From: Anita Gardner
Sent: 09 January 2012 14:25
To: Planning.Responses
Subject: FW: LU/245/10 Repositioning of security fencing to boundary, security lighting and construction of additional pontoons West Bank of River Arun

From: Roger Spencer
Sent: 09 January 2012 13:42
To: Anita Gardner
Subject: RE: LU/245/10 Repositioning of security fencing to boundary, security lighting and construction of additional pontoons West Bank of River Arun

RIVER ARUN

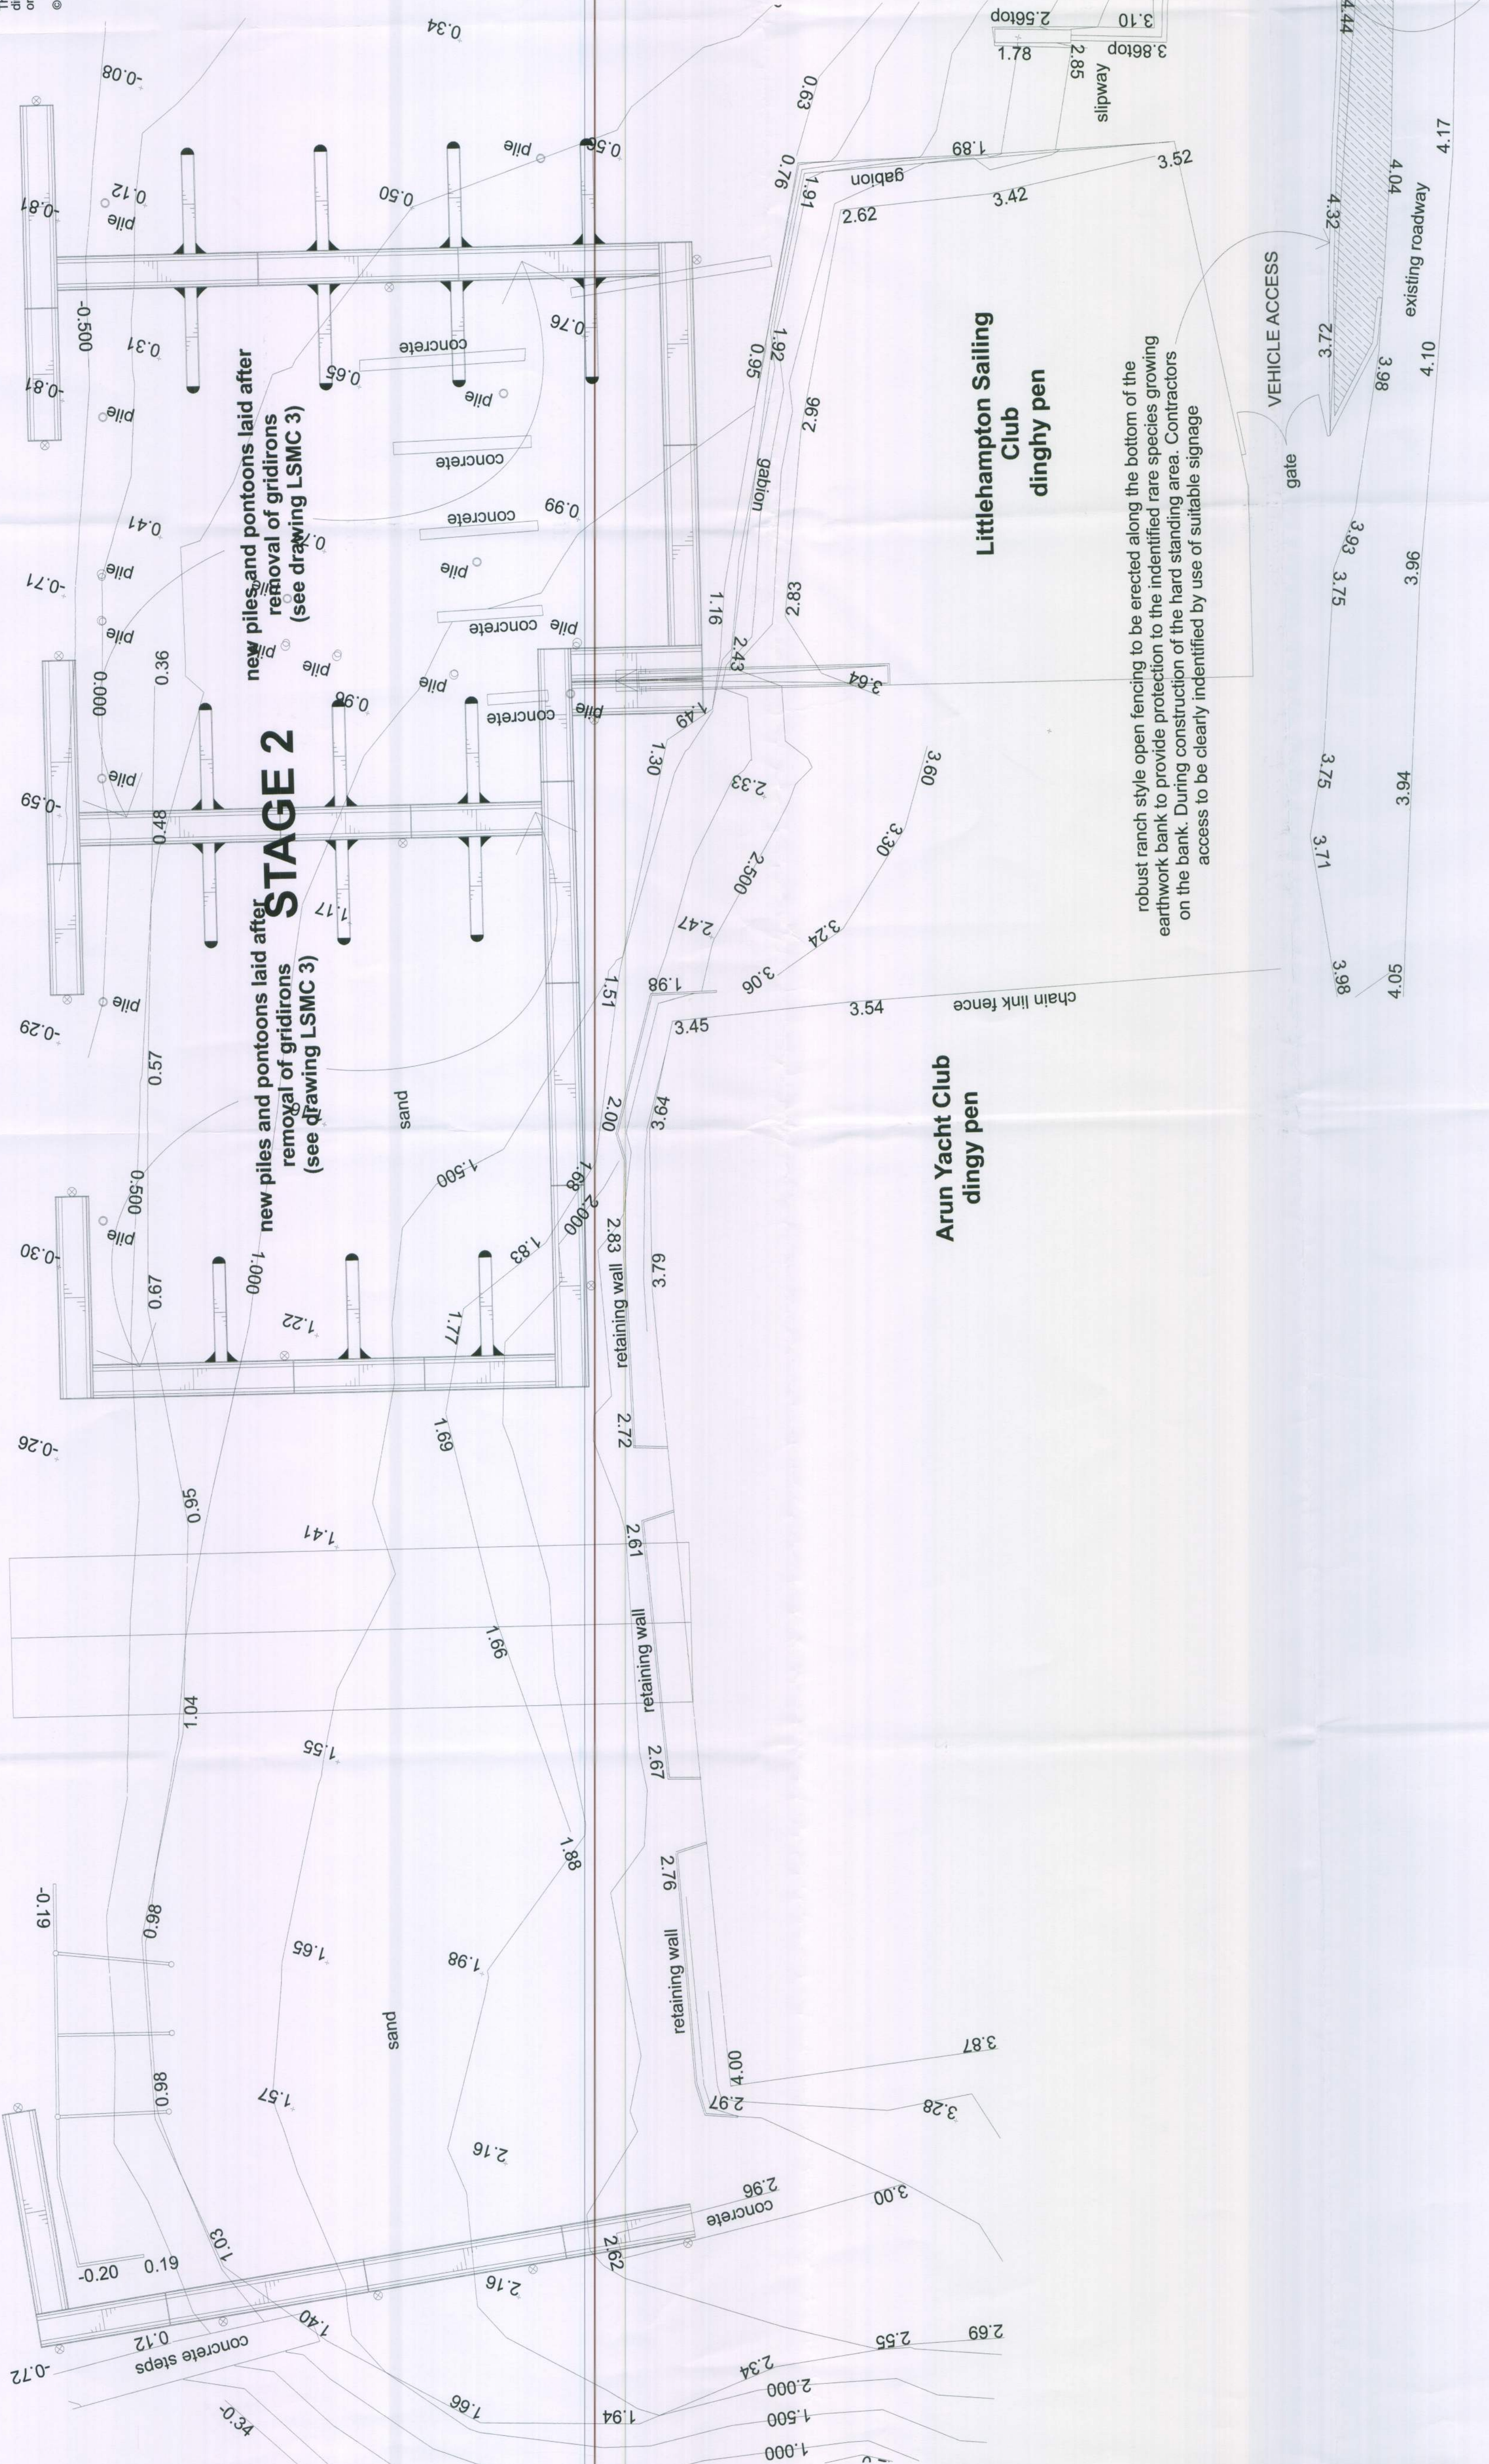
However, if you recall, I did have concerns that elements of the application might be below High Water Mark and that the information shown on the submitted drawings did not provide sufficient information to establish this or not. Arun could be considering aspects of the application that might be, as I understand it, outside of the Council's remit in terms of planning permission.

Roger,
 I could add an 'Informative' on any permission stating that the planning permission relates only to works above High Water Mark and that any works below this level would be subject to consent from other relevant authorities. Would this satisfactorily address your concerns?
 Anita
